From: Laura Gibbons [REDACTED]
Sent: 28 September 2020 11:08
To: Michael Eastham <Michael.Eastham@arun.gov.uk>
Cc: Planning.Responses <Planning.Responses@arun.gov.uk>
Subject: Re: A/109/20/RES - Land South of Water Lane, Angmering

Thank you for sending us the plans. Our holding objection remains, I have the following comments on the drainage strategy and details supplied:

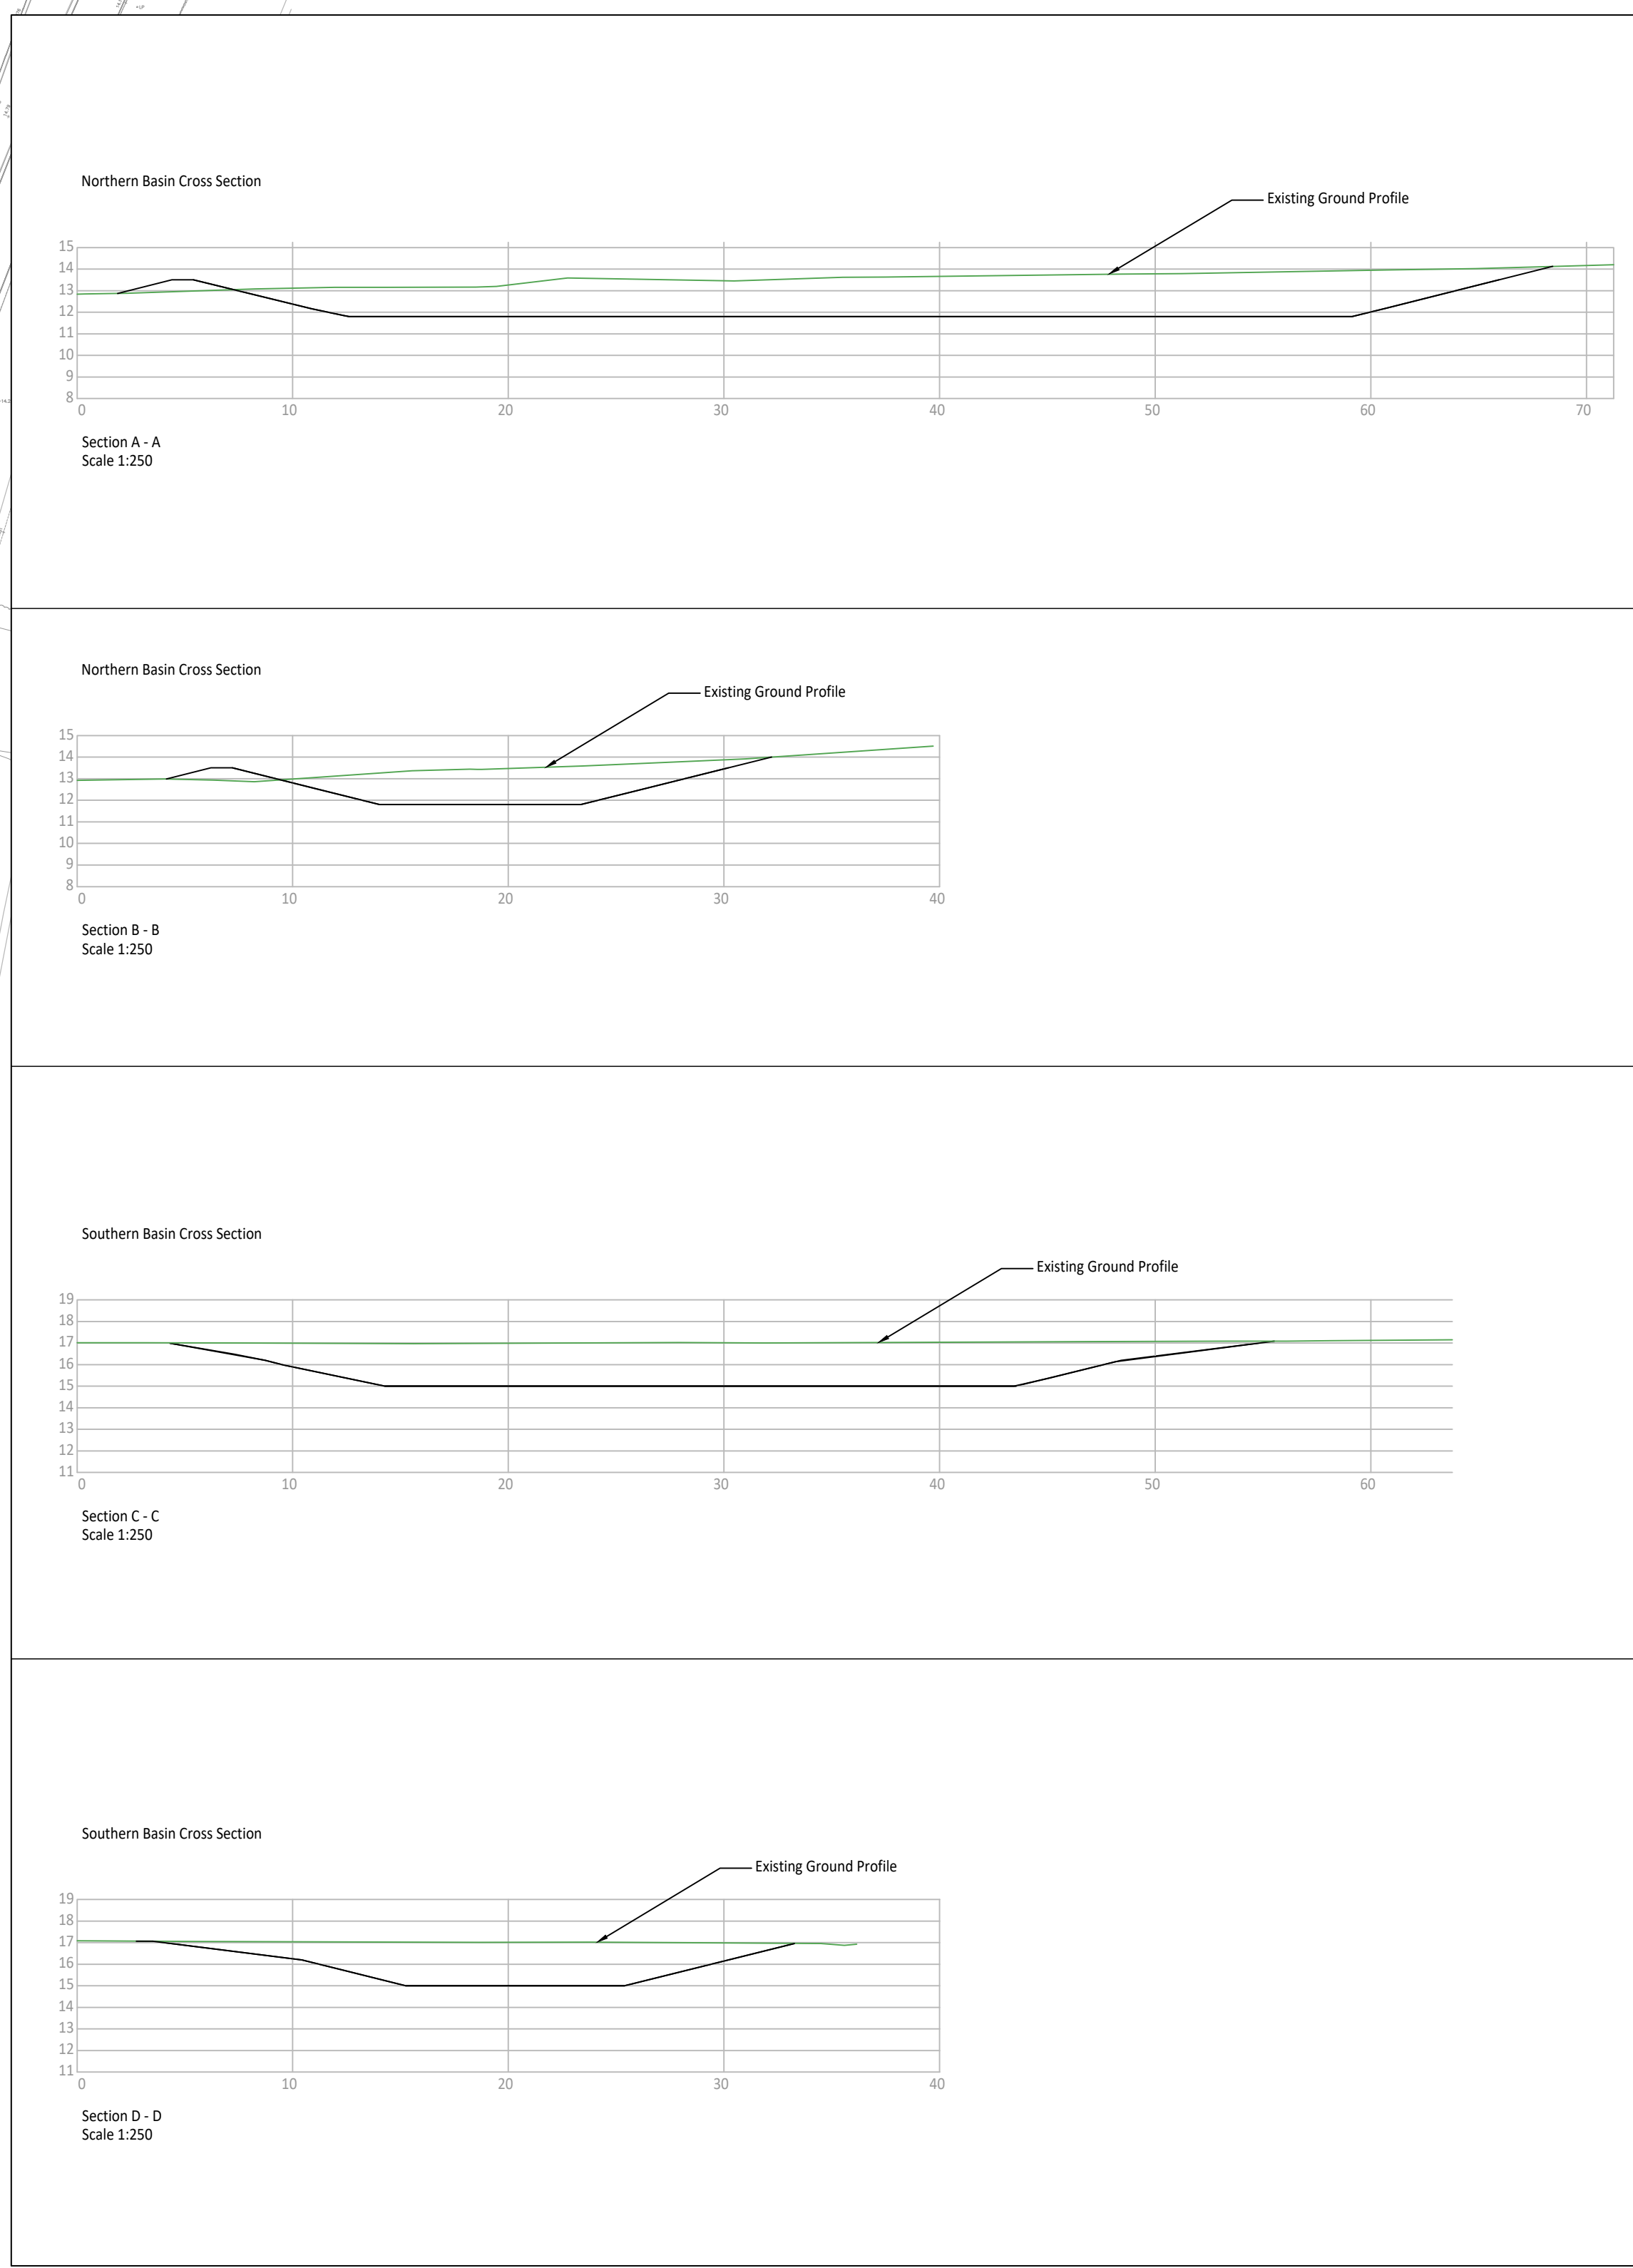
9. Hydrobrake reference numbers need to be detailed on plan and be consistent with calculations.
10. Size of attenuation crates needs to be detailed on plan.

14. Please provide a plan showing a clear 3m buffer around basins.
